FAO: Planning Department,  
Welwyn Hatfield Borough Council

Ref: 6/2018/0136/LB  
Date: 22/10/2019

## HISTORIC BUILDINGS AND CONSERVATION ADVICE

**RE: *Oshwal Centre, Coopers Lane, Northaw, Potters Bar, EN6 4DG***

Scale 1:10

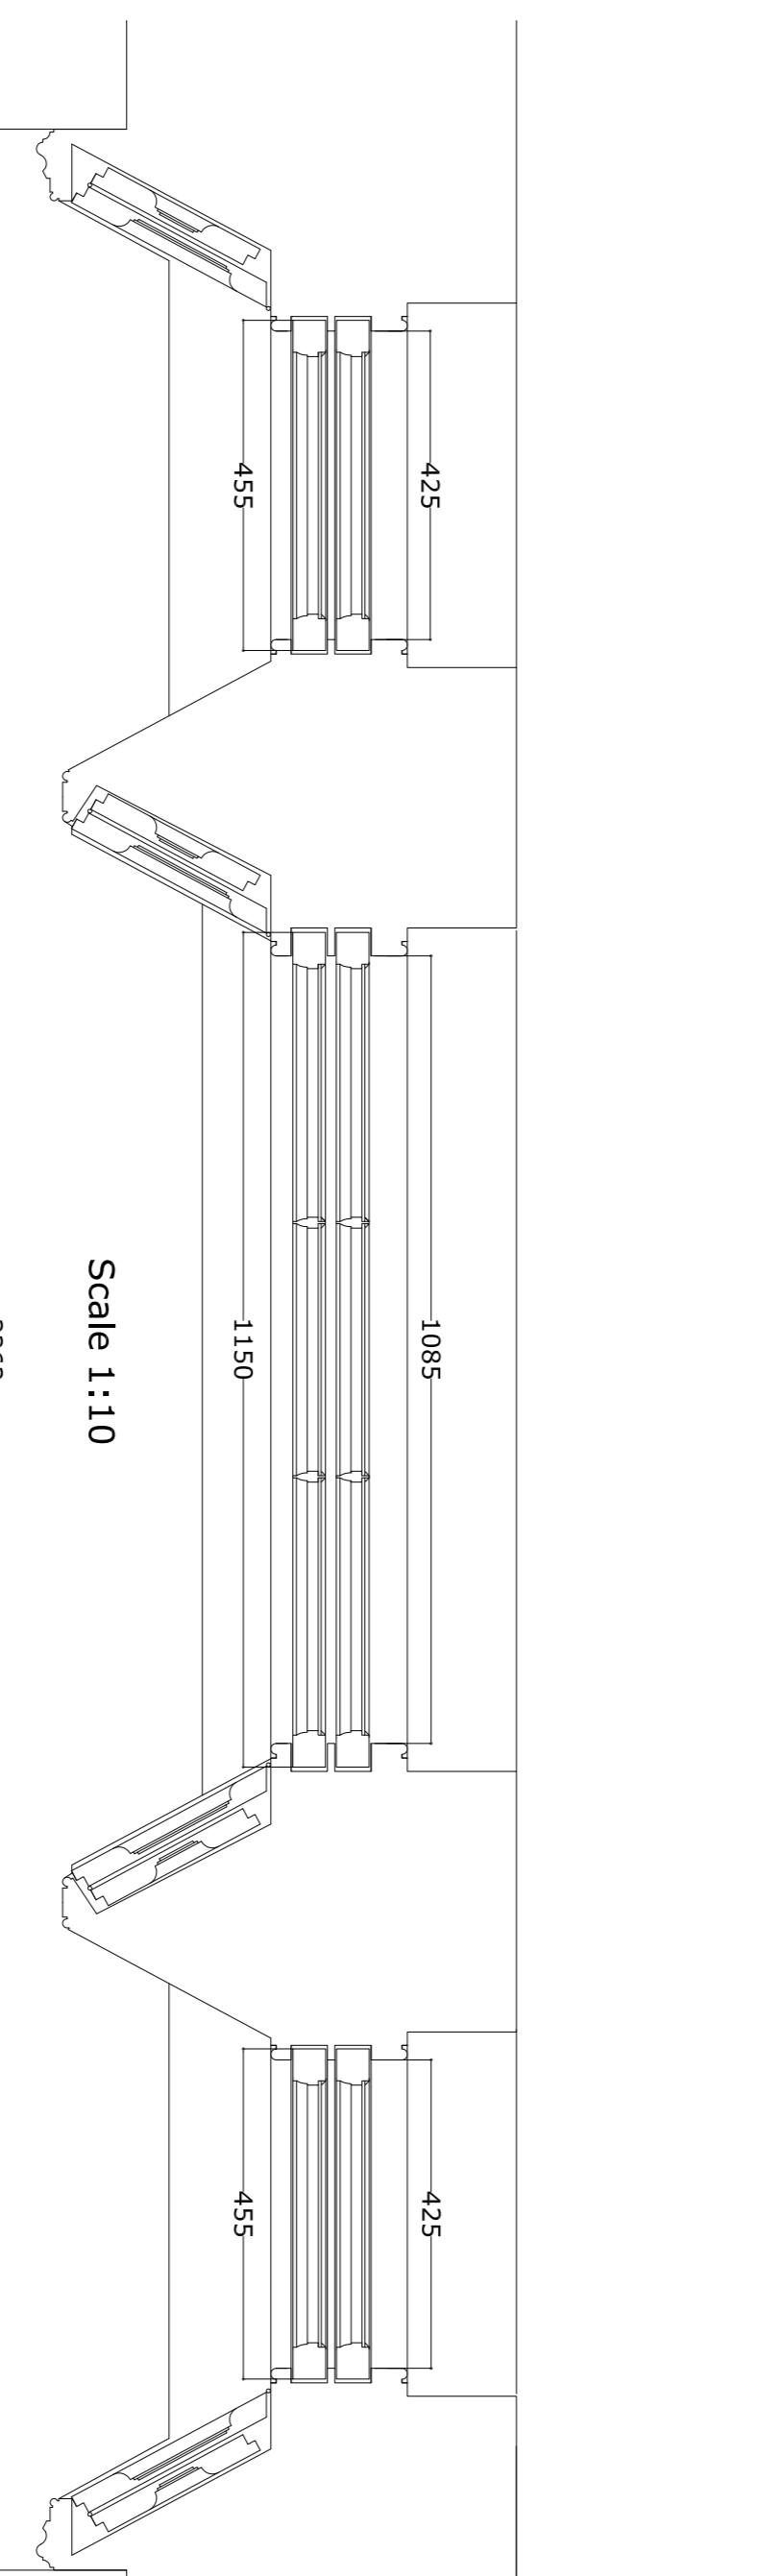
The repair of window nos. 1, 2, 3, 12, 13, 14, 15, 16, 17, 18, 20, 21, 22, 23, 24, 25, 26, 38, 39, 40, 41, 42, 43, 44, 45, 46, 47, 48 (refer to paragraph no. 2.11 of the *Heritage Statement Annex 1* and drawing no. 6842-78-P0) is supported. These windows appear to be original to the 1839 section of the house and therefore relate to the primary phase of the building. However, further detail is required on the repair needed to these windows as the *Heritage Statement* is quite general. Detail is required as to the extent of the repair work, the technique/methodology materials to be used. The proposed replacement of the single glazing with slim double glazing is not acceptable because of the potential loss of historic glass and the untraditional modern appearance of double glazing.
